**From:** Simon Davis  
**Sent:** 01 March 2019 12:07  
**To:** Planning.Responses  
**Subject:** FW: BR/270/18/PL - 18-20 London Road, Bognor Regis, PO21 1PY

Env Health (Private Sector Housing) Consultation Response

**From:** Louise Crane  
**Sent:** 01 March 2019 10:32  
**To:** Simon Davis <Simon.Davis@arun.gov.uk>  
**Subject:** RE: BR/270/18/PL - 18-20 London Road, Bognor Regis, PO21 1PY

Re BR/270/18/PL – “Part conversion & extension of existing building to provide 6 No. additional storeys over existing rooftop to provide up to 104 No. student residential units with access from Bedford Street, associated servicing & ancillary accommodation, entrance & new internal stairs to existing building to provide access from Bedford Street.”

B1-Store First Floor
1 : 200

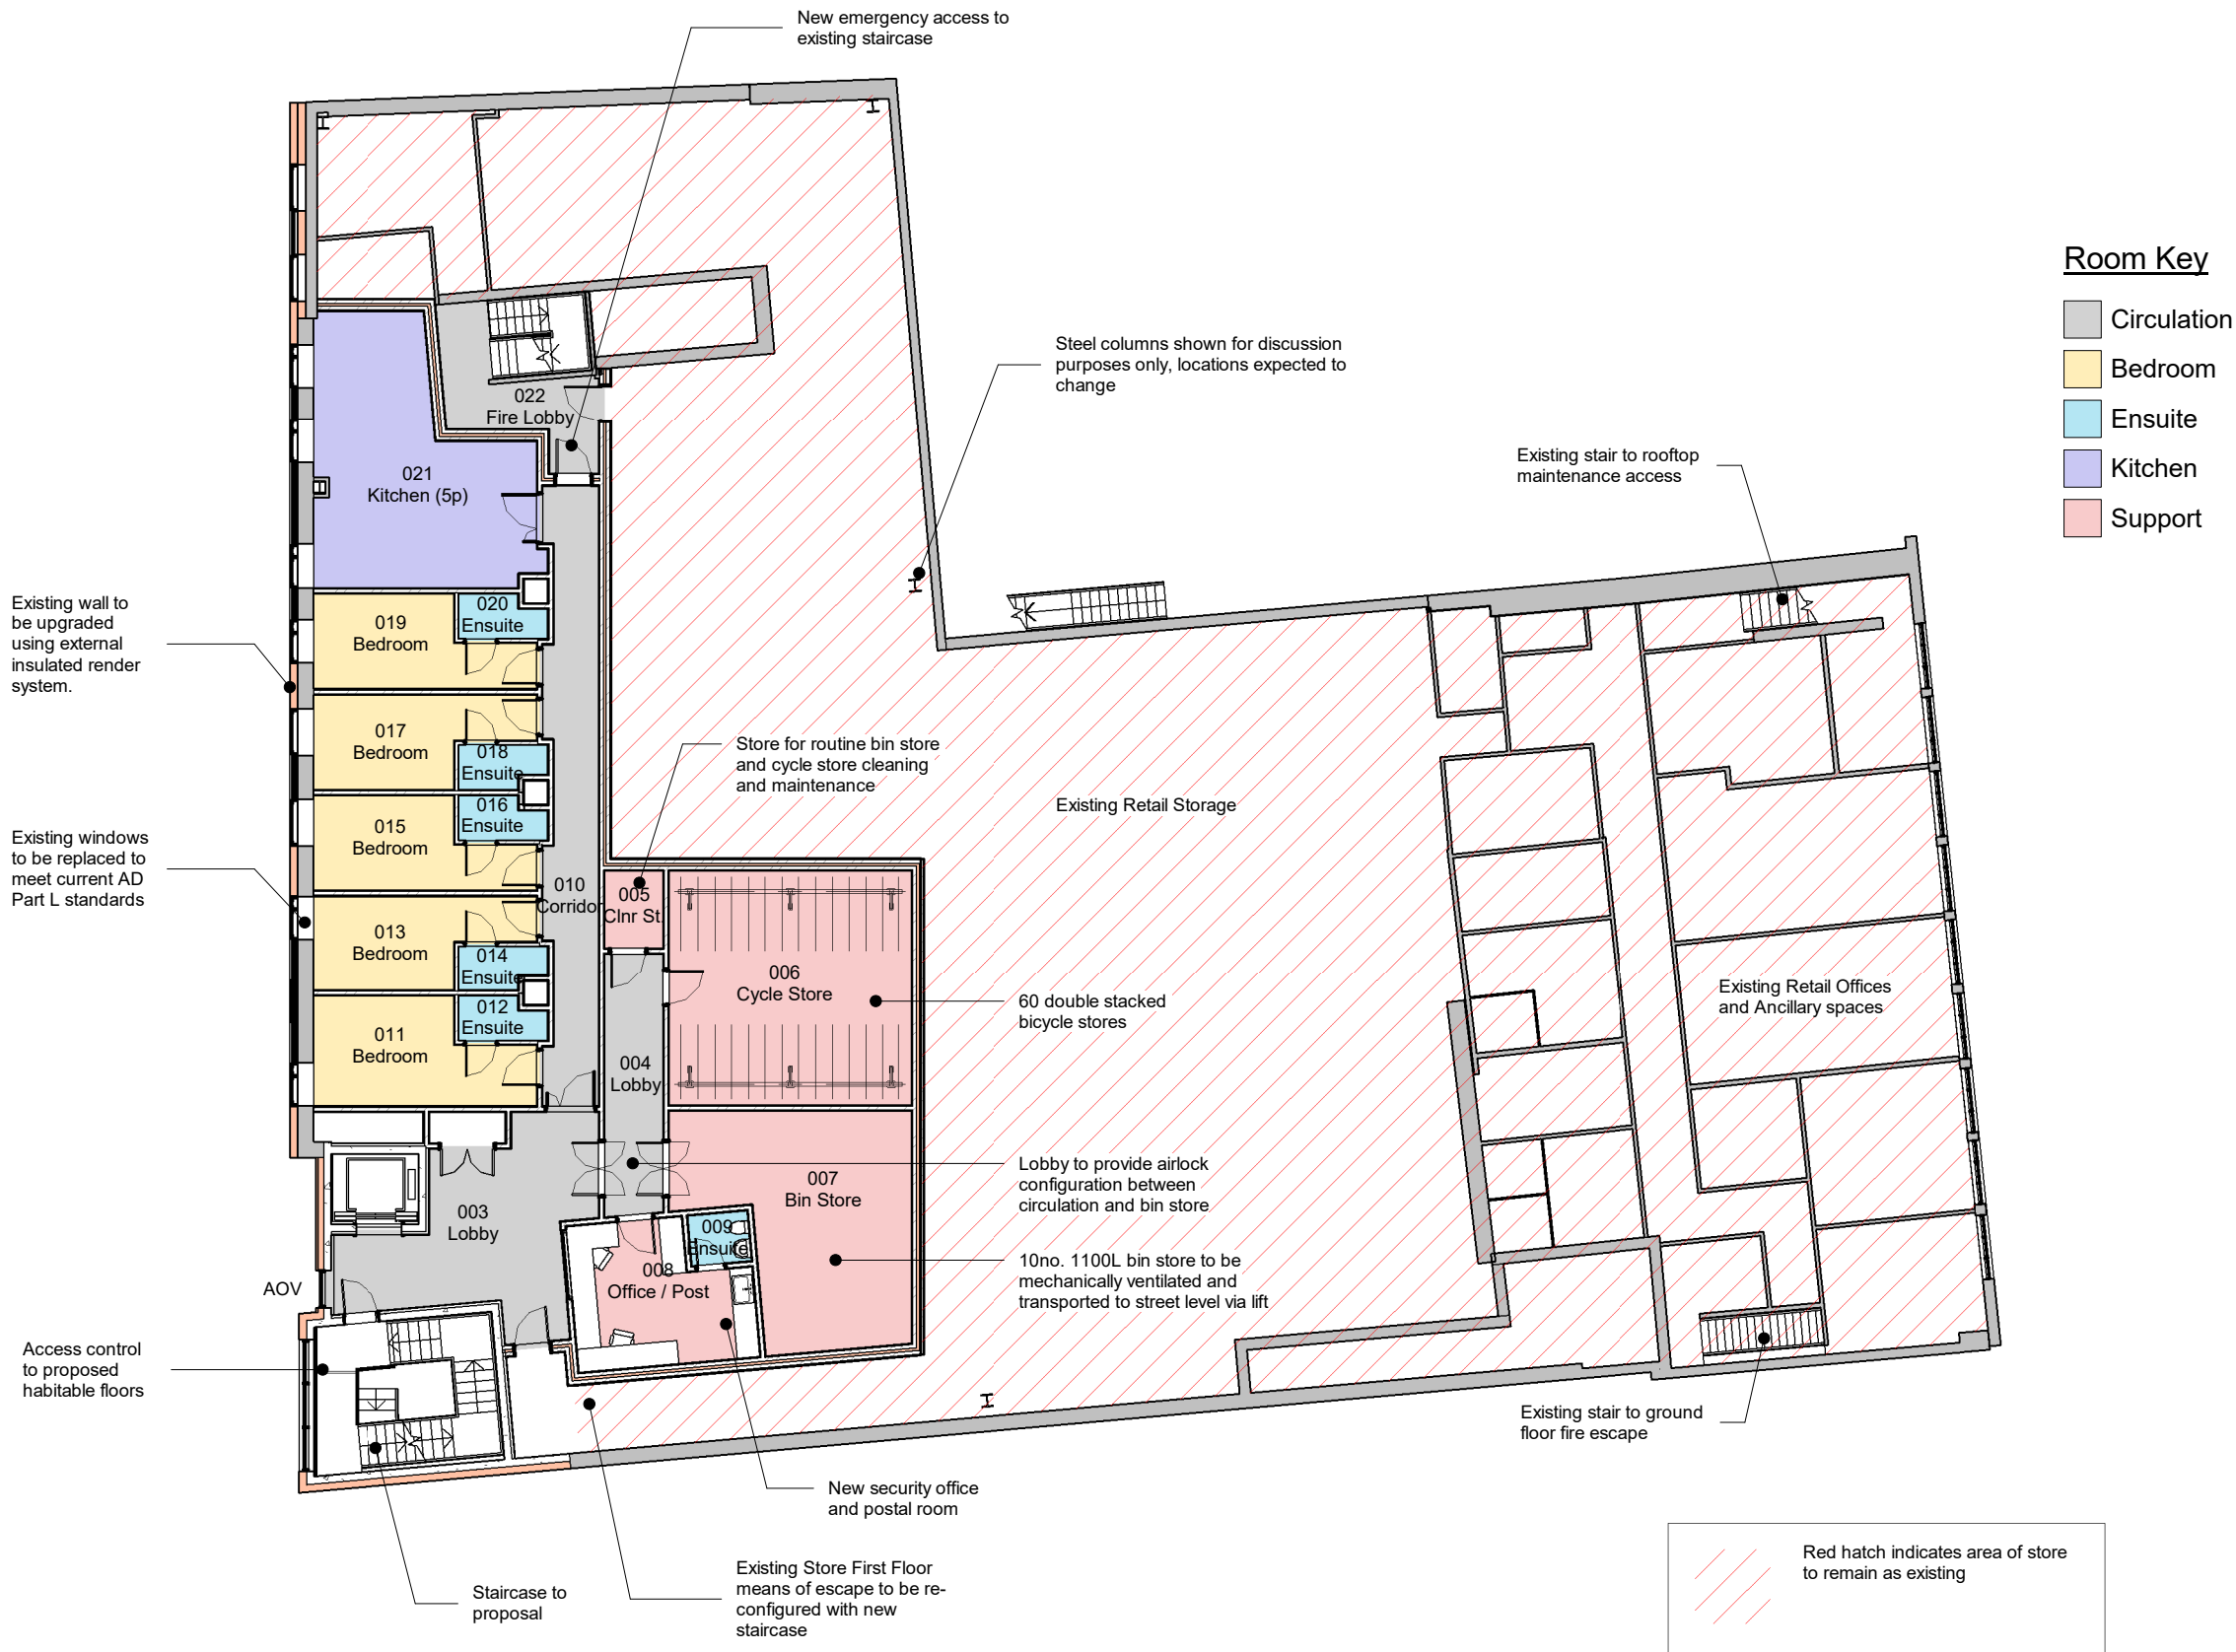
- There is provision for a refuse store which is located on the first floor and collection by the refuse company is internally utilising the lift. I have concerns regarding this arrangement as to whether a refuse company would operate this collection service, if the lift is out of action what are the arrangements, will the same lift be used by the residents, if the residents are requested to put the refuse outside for collection then this could be a considerable amount of waste put on the pavement/roadside for collection which will lead to complaints. Bin stores need to be appropriately managed particularly with this type of internal arrangement to ensure they are cleaned, maintained and do not allow build of waste to help prevent any potential public

health issues. I note that the management plan is to have a live in student warden, however, this may not always be the case if the situation should change or new ownership took over the property.  
Should you require any further information or clarification just let me know.
